**SYDNEY OLYMPIC PARK AUTHORITY
DESIGN REVIEW PANEL
ADVICE SHEET**

Project	3.1 – Site 53, New Residential Development
Presentation / Review Date	22 September 2016
Panel Present	Peter Mould (A/Chair) Bill Tsakalos Caroline Pidcock Prof Linda Corkery Prof Peter Webber
COI Declaration	None. It was noted that Caroline Pidcock and Peter Poulet had participated in the Design Competition Jury.
Also Present	Ben Woods, Darlene van der Breggen, David Martin - SOPA
Presenters	Phillip Rossington – (BVN) Mark Gazy – (BVN) Graham Cooper (Mirvac) Amar Prashant (Mirvac) Alex Black (Mirvac)
Documents made available	Power Point Presentation and A4 handout
Inherited decisions	The SOPA Board has instructed that development should comply with the height restrictions in the Draft Master Plan 2030 (2016 Review) and that no special exceptions be made for site 53.
Previous relevant SOPA Advice	DRP meetings at 19 March and 20 August 2015, 17 March 2016
General Observations/ Overall Comment	The proposal is an amendment to the existing approved design incorporating increases in maximum FSR and building height proposed in the DRAFT MP2030 (2016 Review). The revised design also addressed a number of design iss

SHADOW STUDY

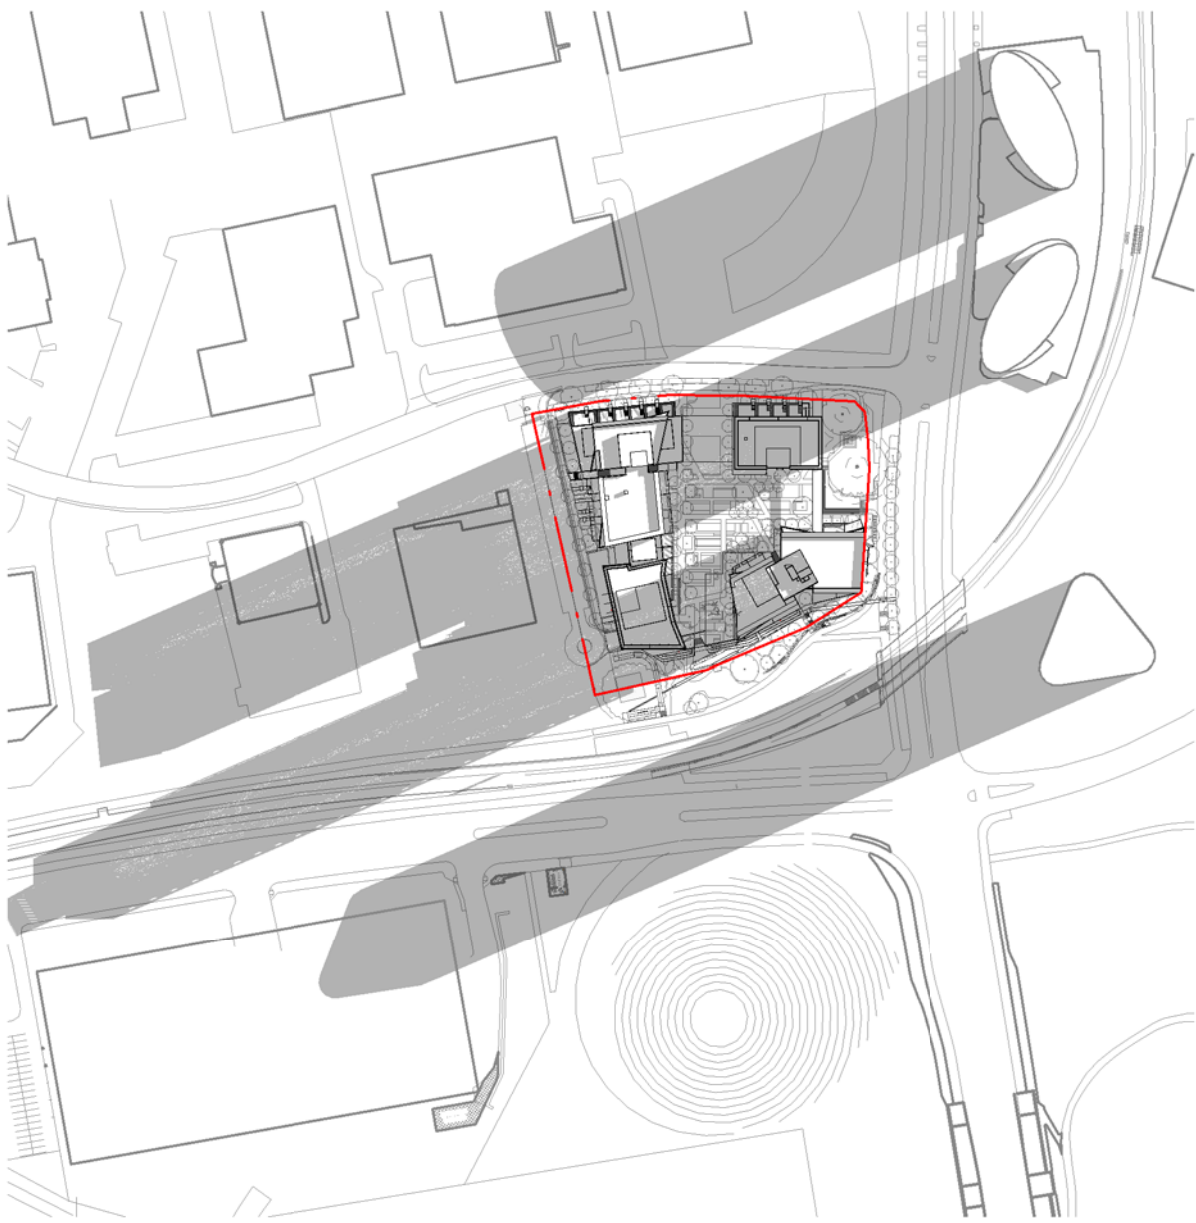
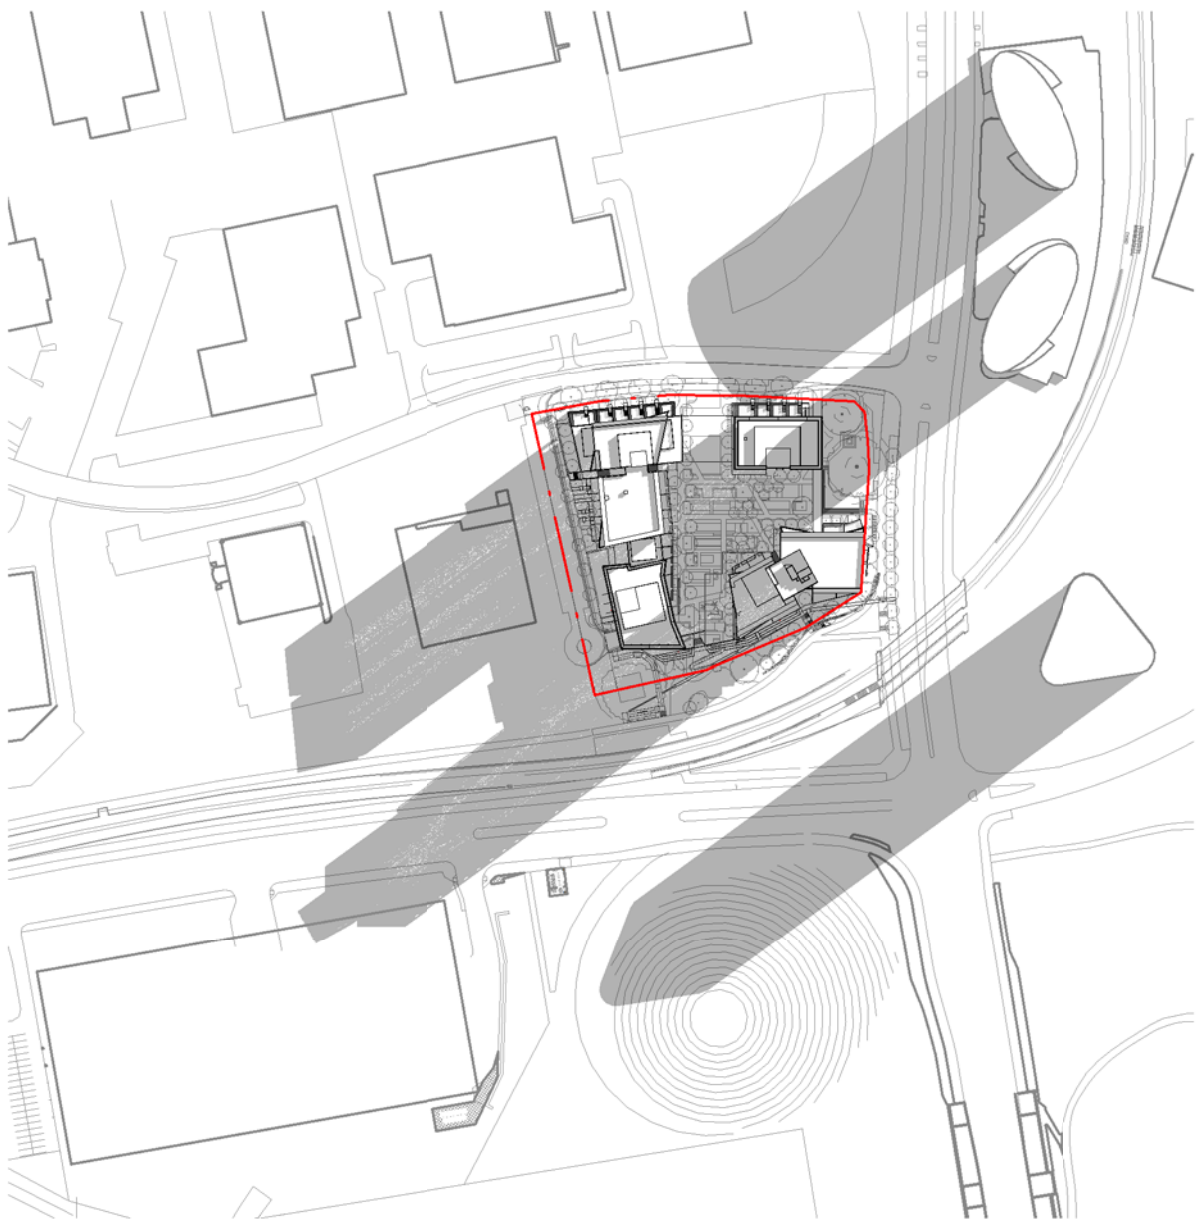
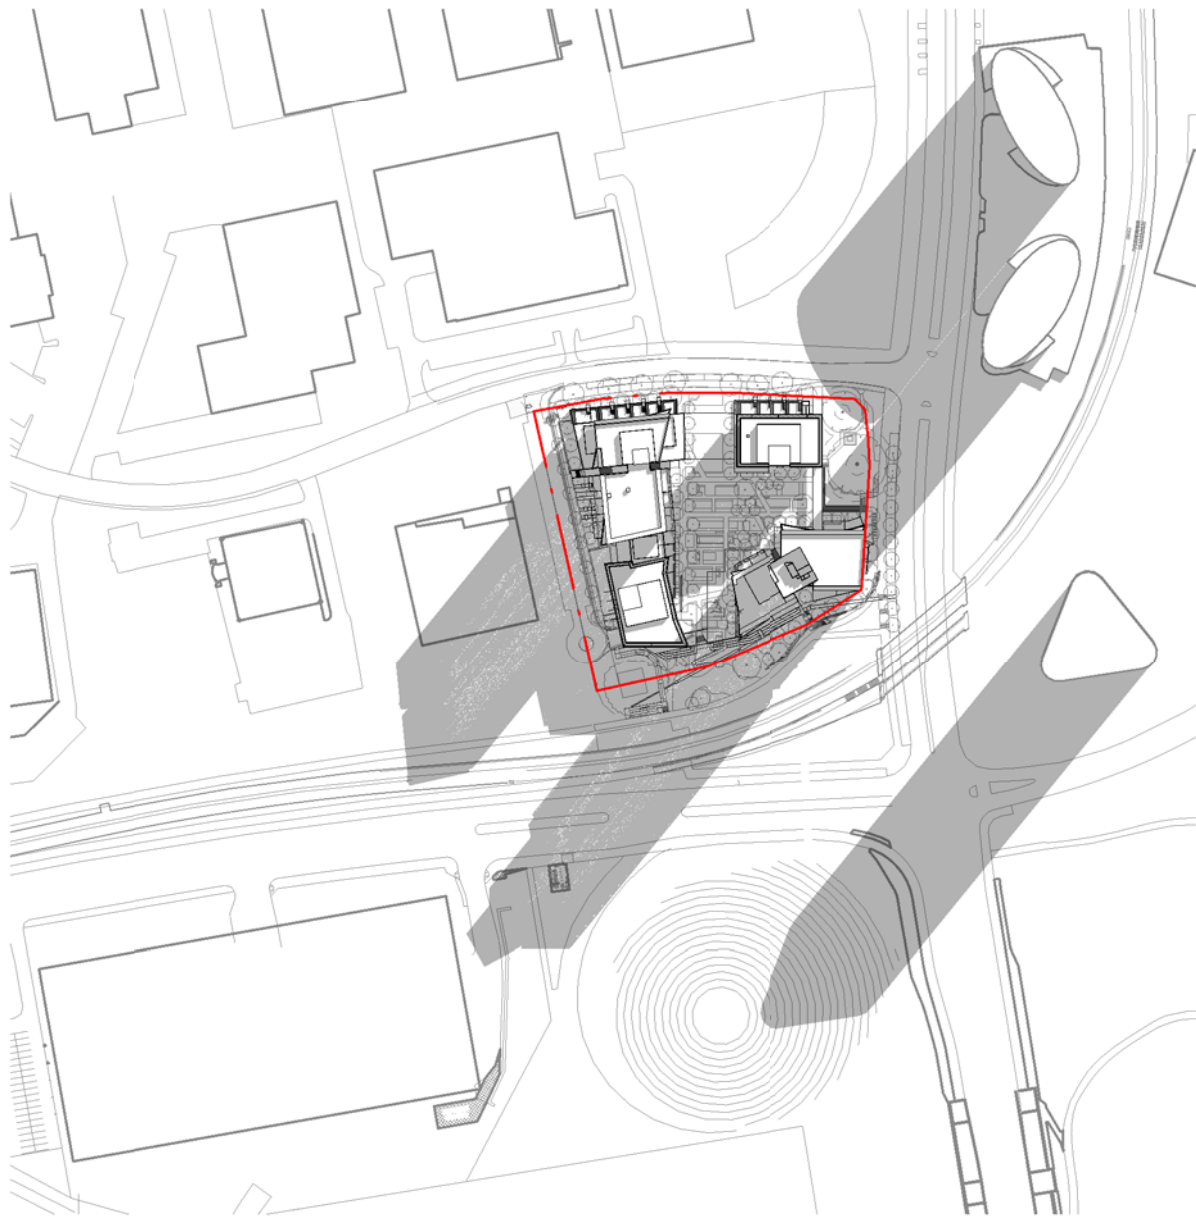
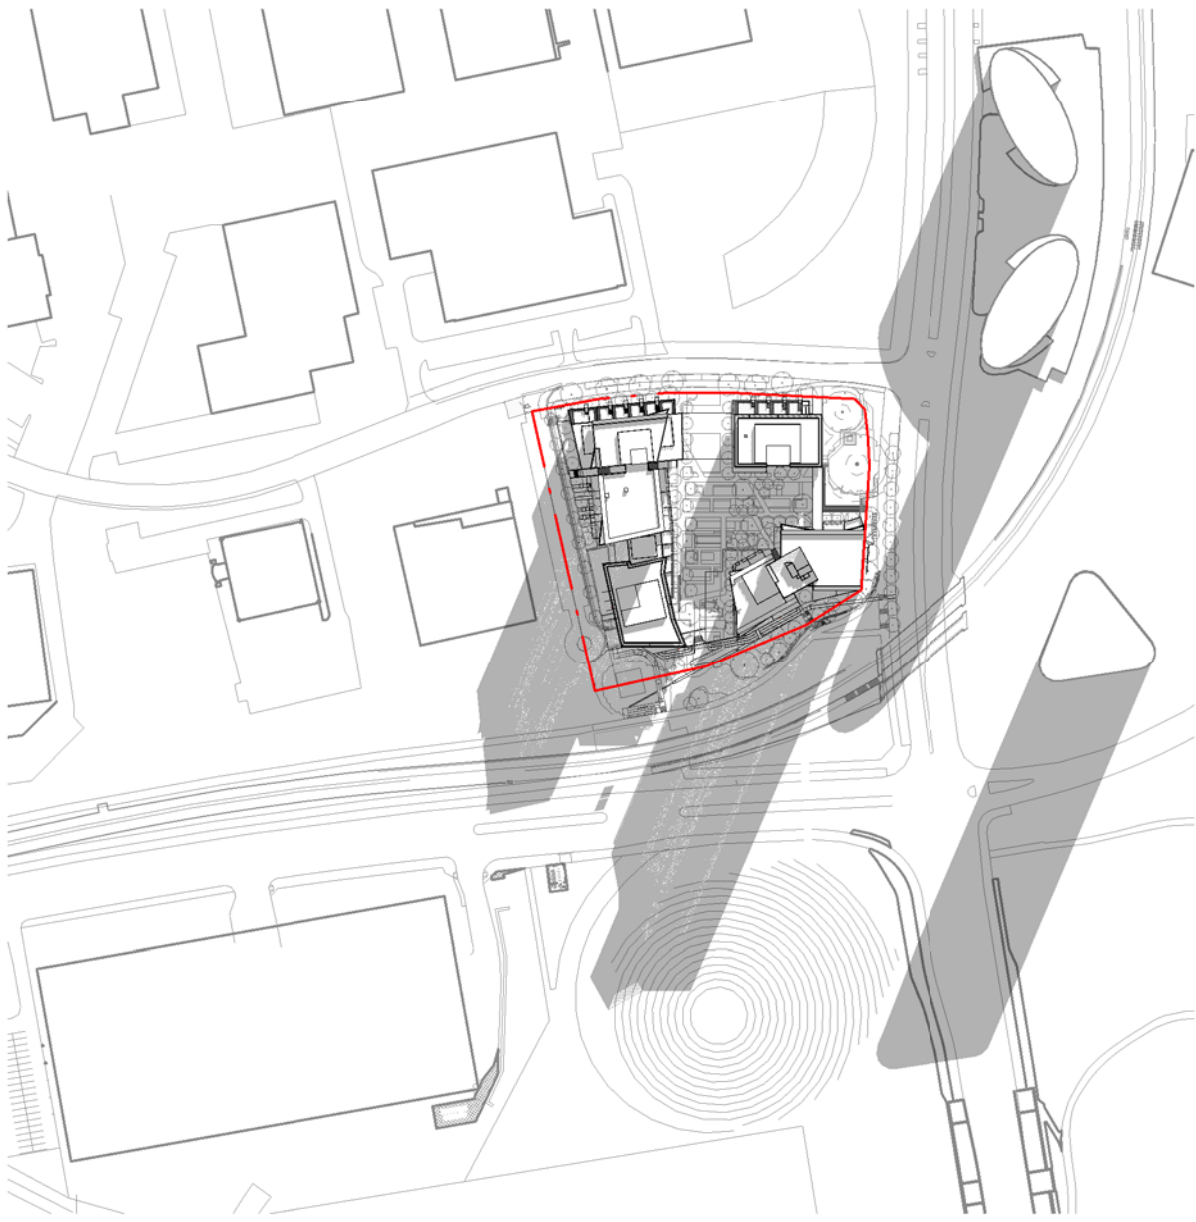
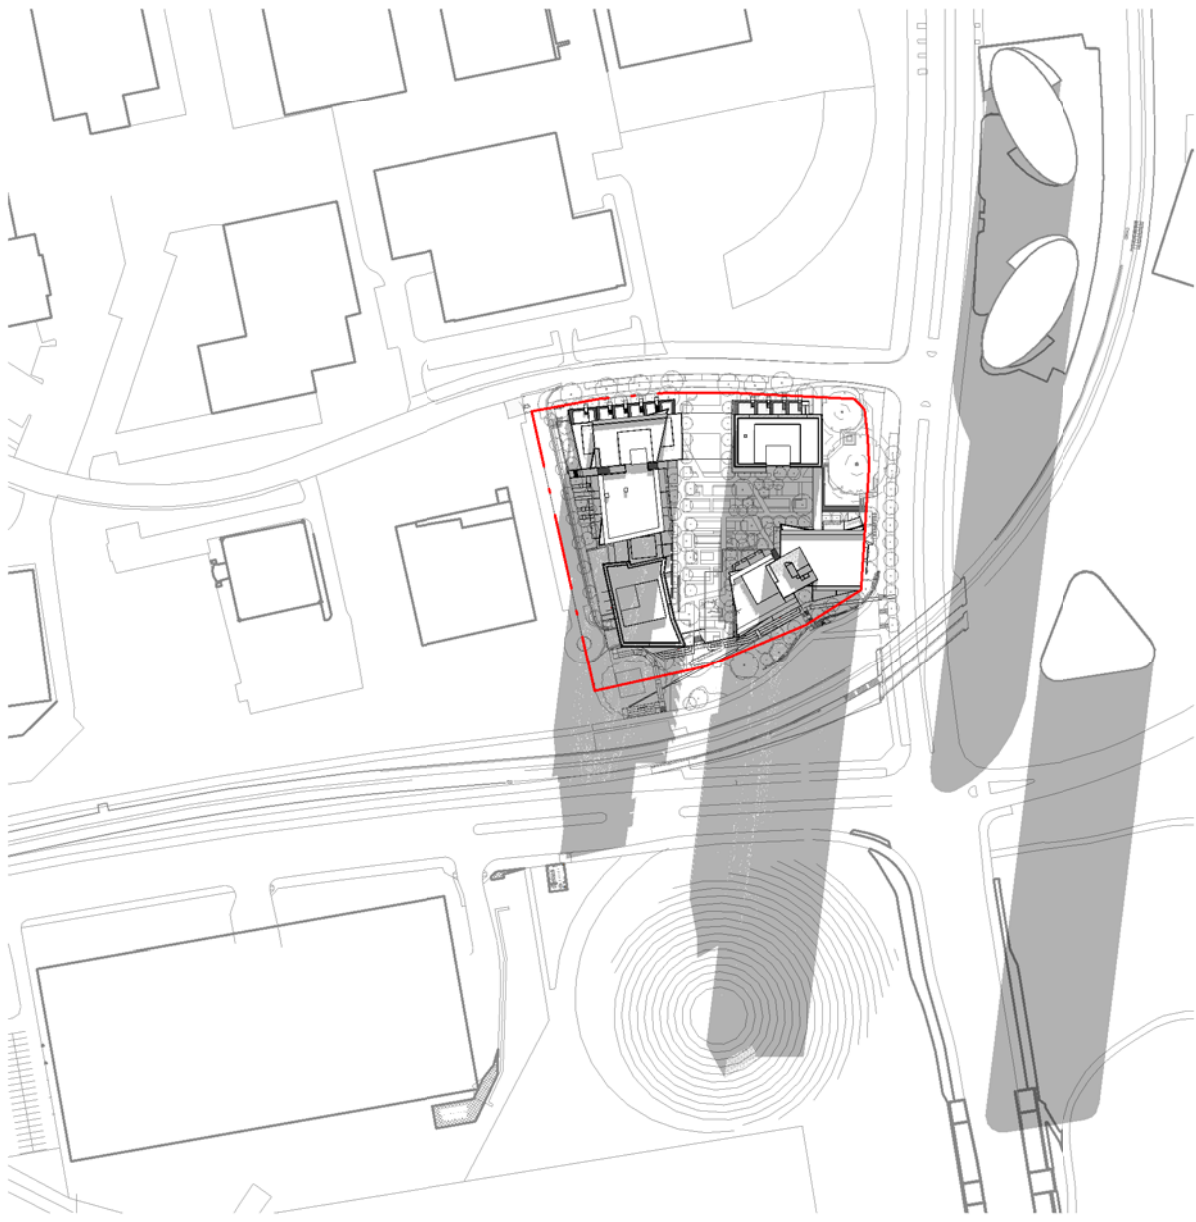
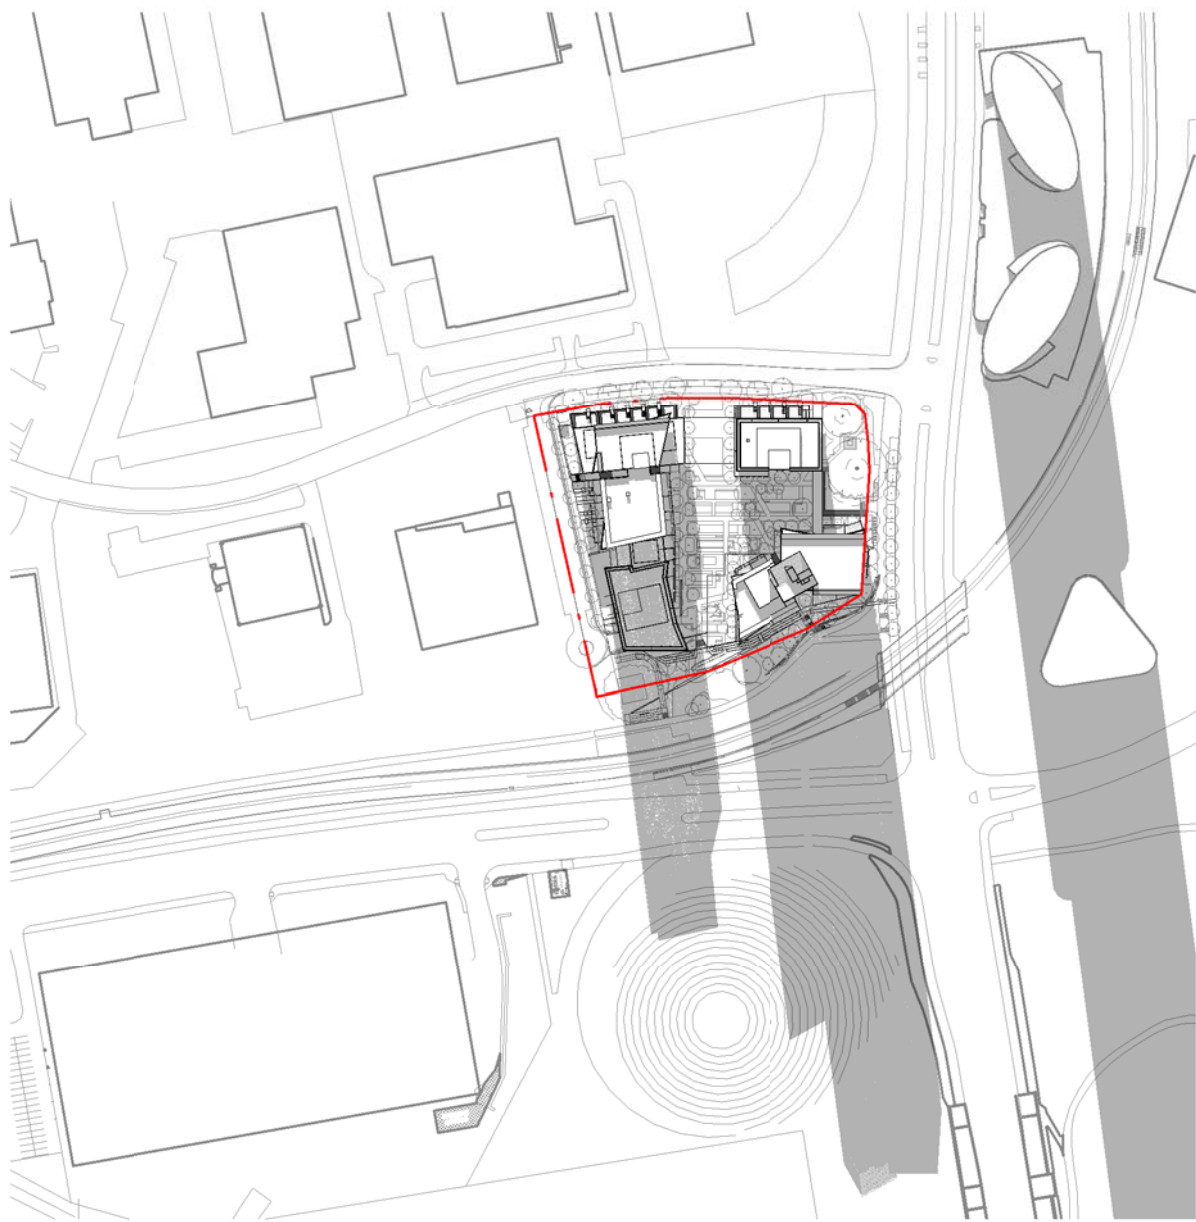
MATERIALITY AND BUILDING EXPRESSION • There is little to differentiate / modulate the ground and lower levels against the tower levels. • Further reduction in the extent of brickwork has resulted in glazing being the dominant architectural language. • the use of brickwork at the plinth only, with minor insertions in the upper levels of the podium, has Is not substantial enough to be meaningful. LANDSCAPE AND PUBLIC ACCESS • The potential for a public through site link continues to be overlooked, especially as this could offset the impact of the substantial density uplift though it is acknowledged this is not a requirement in the Master Plan. • Programming of communal facilities does not seem adequate for the needs of 700 households, eg play area is very small, only one communal area. • The path connections into and through the linear park are too indirect, eg walkway around the transplanted fig tree at the end of New street. BUILDING SETTING • There was little detailed information on the resolution and integration of setbacks and edges along all three street frontages and the linear park. OTHER • Large number of units accessed from each lift core will discourage neighbourly / community interaction. • The percentage of units achieving 2 hours of sunshine on June 21 has decreased, while the number achieving flow through ventilation was uncertain.
